THIRU PAVAN RAINA, I.A.S.,
Member-Secretary,
Madras Metropolitan
Development Authority,
No.8, Gandhi-Irwin Road,
Egmore, Madras-600 008.

Lr.No.C4/9006/91

Sub: MMDA - Planning Permission - Regularisation
of existing school building and proposed
additional construction of School building
in S.No. 202/1E, 1F, 2G, 202/2 and 203/2
of Mogappair village - Remittance of
Development Charges - Requested - Regarding.

SITE PLAN
 SCALE 1"=240'

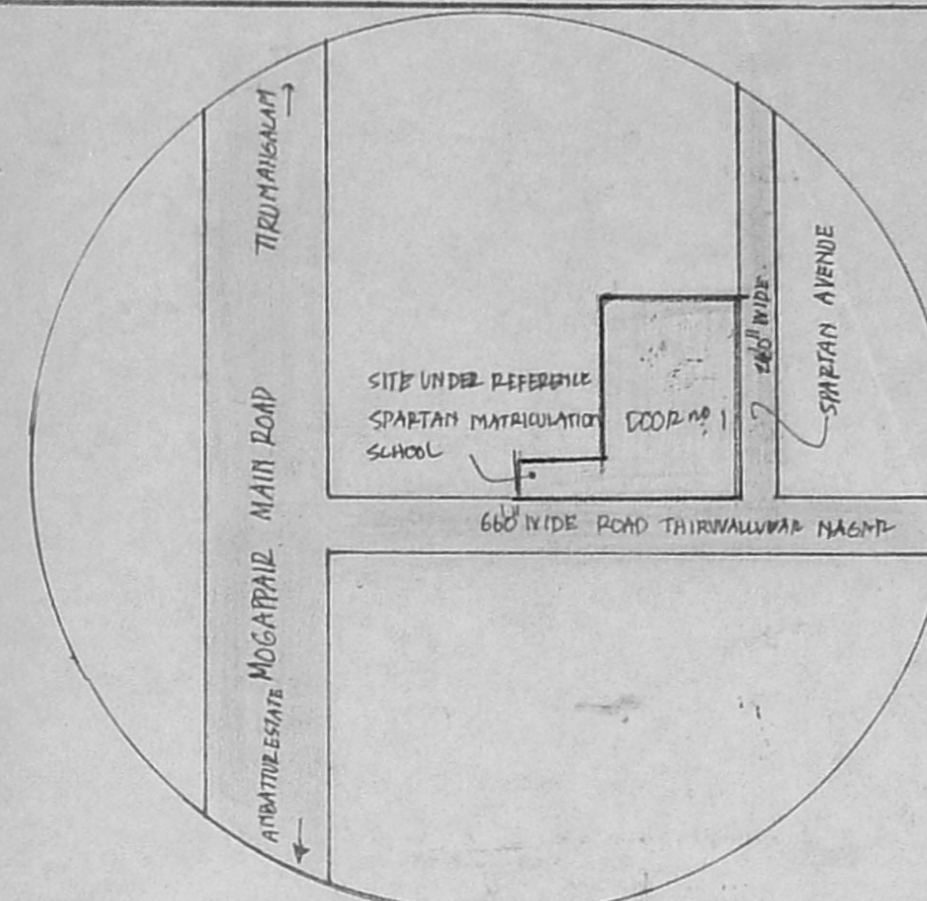
2. In this connection, you are requested to remit a sum
of Rs. 2,350 + 3,200= Rs. 5,550/- (Rupees Five thousand five hundred
and fifty only) towards Development Charges for land and building
and Rs. 350/- (Rupees Three hundred and fifty only) towards
Scrutiny charges and Rs. 8,400/- (Rupees Eight thousand and four
hundred only) towards Regularisation of unauthorised sub-division
charges by a Demand Drafts of any nationalised bank in Madras,
drawn in favour of the Member-Secretary, MMDA and the same may be
remitted at the cash counter of the MMDA within ten days on receipt
of this letter. You are also requested to furnish an undertaking
deed, Revised Affidavit duly notarised, and 5 copies of Revised site
plan deleting the Gate at splay.
